Re: Mason Ridge Entrance Monument
Harnett County Planning Services
Revision 1
Site Address: 20 Fair Child Rd. Spring Lake, NC 28390
Project #: 2411-0003

Thank you for your plan review comments, dated November 27, 2024. On behalf of **D.R. Horton – Central Carolina**, please find our review comment responses provided below. Please find our responses to the review comments provided below, **in blue bold text**, following the original comment.

**H1.0**

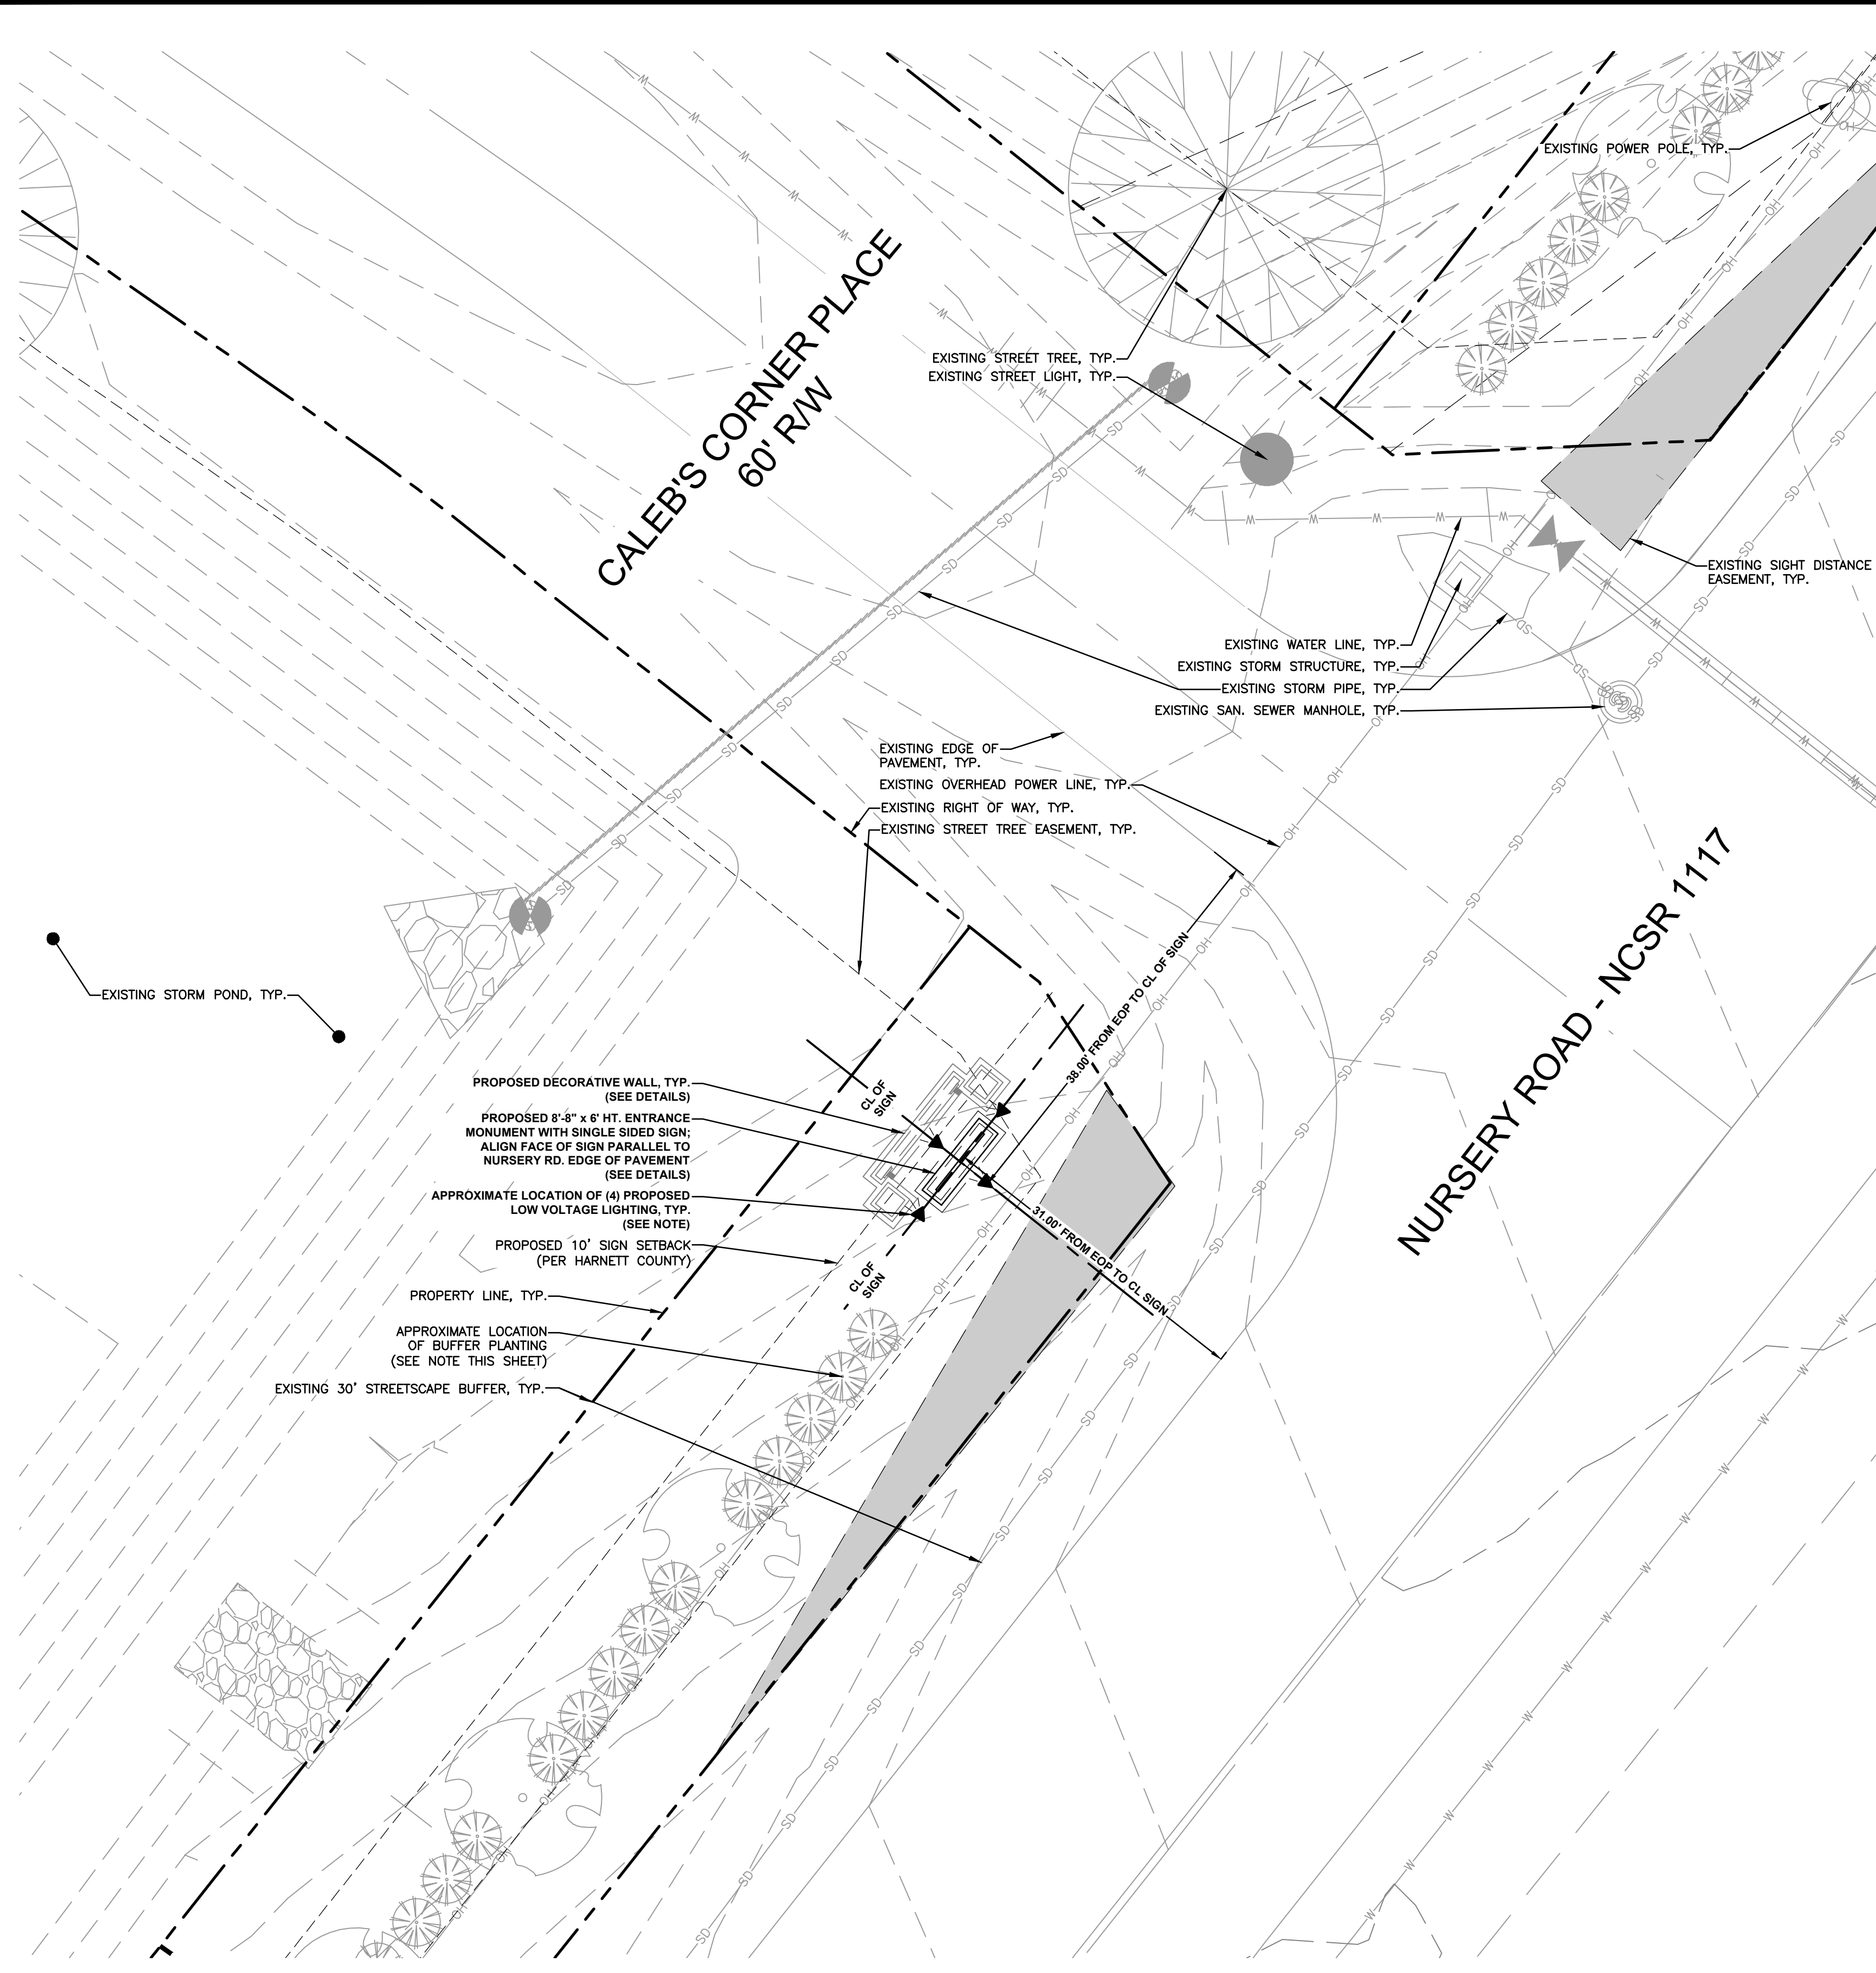
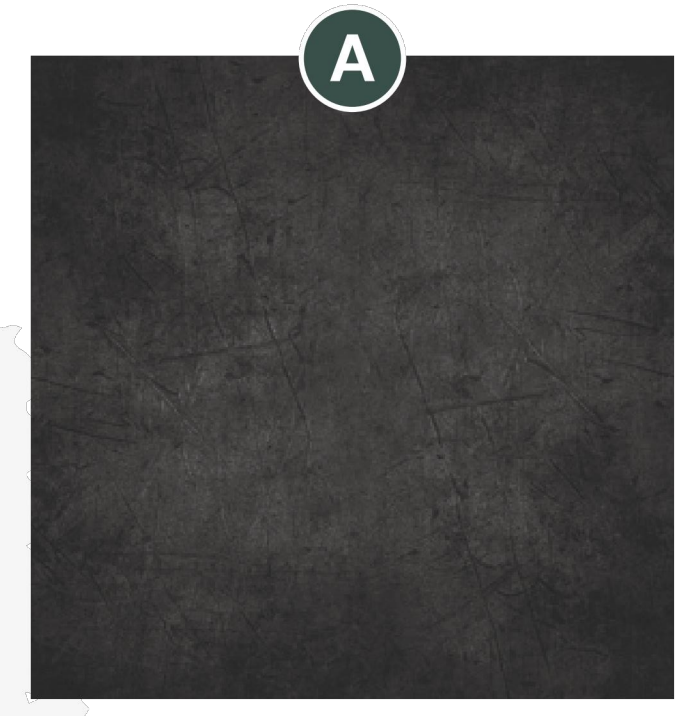
1. Please remove the sign from the rear setback area. There is a 10' setback required from each edge of ROW, and 20' from the intersection.

ESP RESPONSE: As discussed via email dated 12/13/2024, the monument has been relocated to be setback a minimum of 20' from Caleb's Corner Pl., 10' from Nursery Rd. and 10' from any adjacent property lines.
